## GG119 ROAD SAFETY AUDIT RESPONSE REPORT

Project Title:	Units 19-20 Headfield Mills, Savile Town, Dewsbury
Project Team:	TPS Consultants Ltd
RSA Report Stage	Stage 1
RSA Organisation:	Road safety initiatives
RSA Report Reference:	RSI-MH-0725-008 Issue 1.0
RSA Report Issue Date:	13.12.25
Report Title:	<u><a href="#">Units 19-20 Headfield Mills – RSA Response Report</a></u>
Reference:	P3144_20260226_Units 19-20 Headfield Mills_RSA Response Report

This Road Safety Audit Response Report results from a Stage 1 Road Safety Audit carried out on the proposed highway works for the parking at land adjacent to Unit 19-20, Headfield Mills, Savile Road, Dewsbury. The scheme includes the provision of a dedicated entry and exit into an area of parking, west of Savile Road.

INFORMATION			
Scale @ A1	Date Created	Drawn	Checked
1:200	29.09.25	JA	JT
TPS Project Number P3144		Revision B	
Drawing Number P3144 - D - 1001

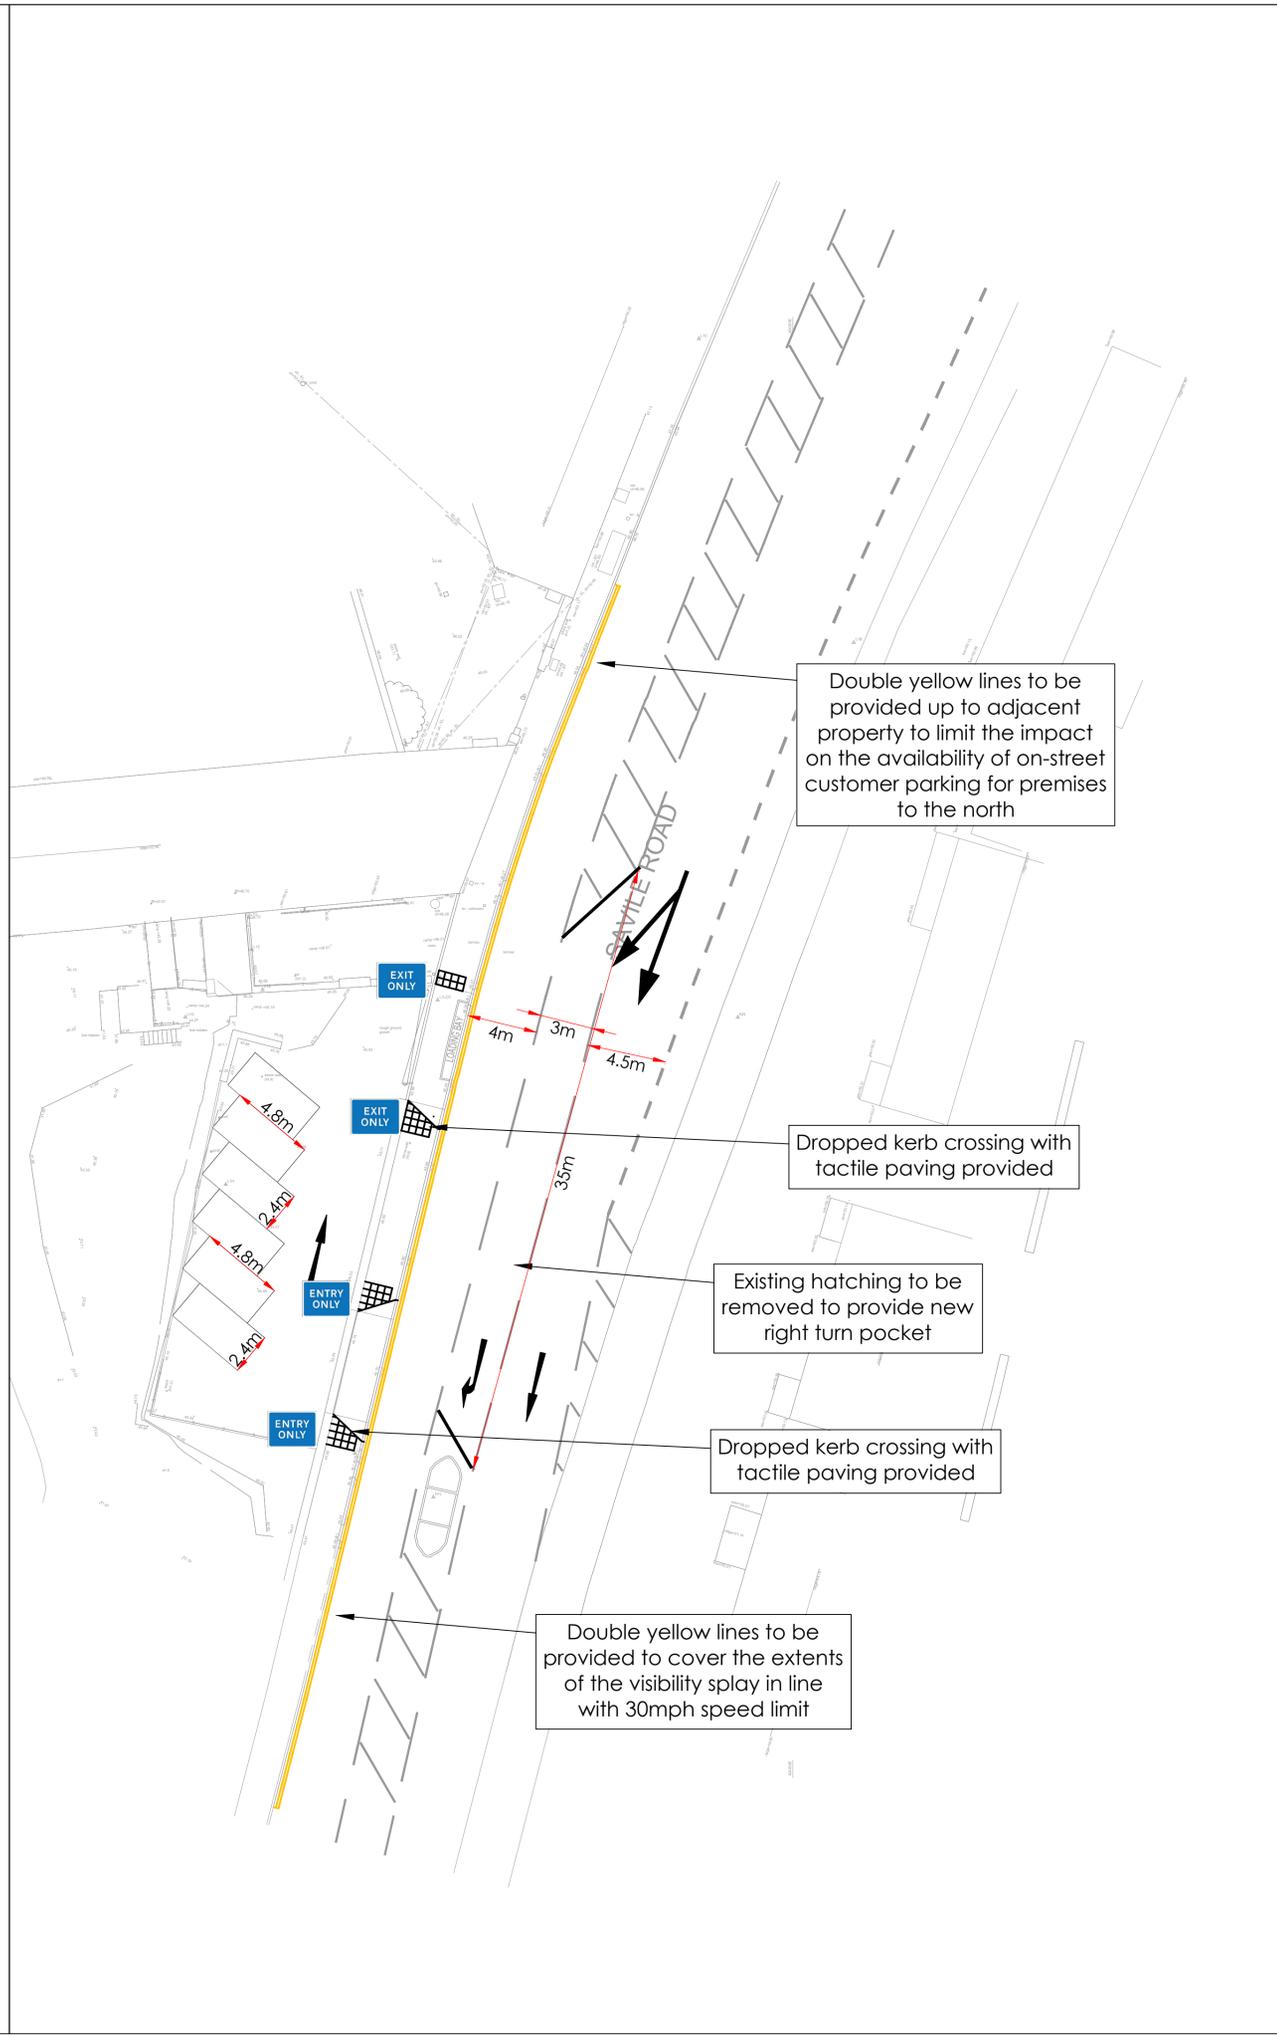
<p><u>Road Safety Audit Problem and Recommendation</u></p> <p><b>Problem 3.1.1</b> <i>Location: Savile Road – Car Park Accesses</i> <i>Summary: Proposed access arrangements may lead to conflicts.</i> <i>Detail: The geometric details of the new car park's entry and exit are unclear. Inadequate widths and radii may restrict 'turning' movements. This may result in a larger car needing several manoeuvres (forward and reverse gears) to turn into / out of the car park, which may lead to vehicle-to-vehicle conflicts.</i></p> <p><b>Recommendation</b> It is recommended that a swept path analysis demonstrates that vehicles can successfully and comfortably turn into / out of the car park.</p>
<p><u>Design Team Response</u></p> <p>Agree. Swept path analysis has been undertaken and is attached to this Response Report demonstrating a large car accessing and egressing the proposed car park in all directions.</p>

<p><u>Overseeing Organisation Response</u></p>
<p><u>Post-RSA Action</u></p>
<p><u>Road Safety Audit Problem and Recommendation</u></p> <p><b>Problem 3.2.1</b> <i>Location: Savile Road – Car Park Accesses</i> <i>Summary: Vehicle / pedestrian conflicts are possible</i> <i>Detail: The details of the 'in' and 'out' at the car park are unclear along with the crossing points or modified footway arrangements. In the absence of dropped kerbs, pedestrians may trip and fall stepping up or down from full height kerbs or be vulnerable should they spend longer in the carriageway when crossing the entry or the exit.</i></p> <p><b>Recommendation</b> It is recommended that dropped crossings (with tactile paving) are provided or continuous footway. Including but not limited to:</p>
<p><u>Design Team Response</u></p> <p>Agreed. The proposed access arrangement drawings have been updated to include a dropped crossing with tactile paving on Savile Road, across both the entry and exit to the site. The revised drawings are attached to this report.</p>
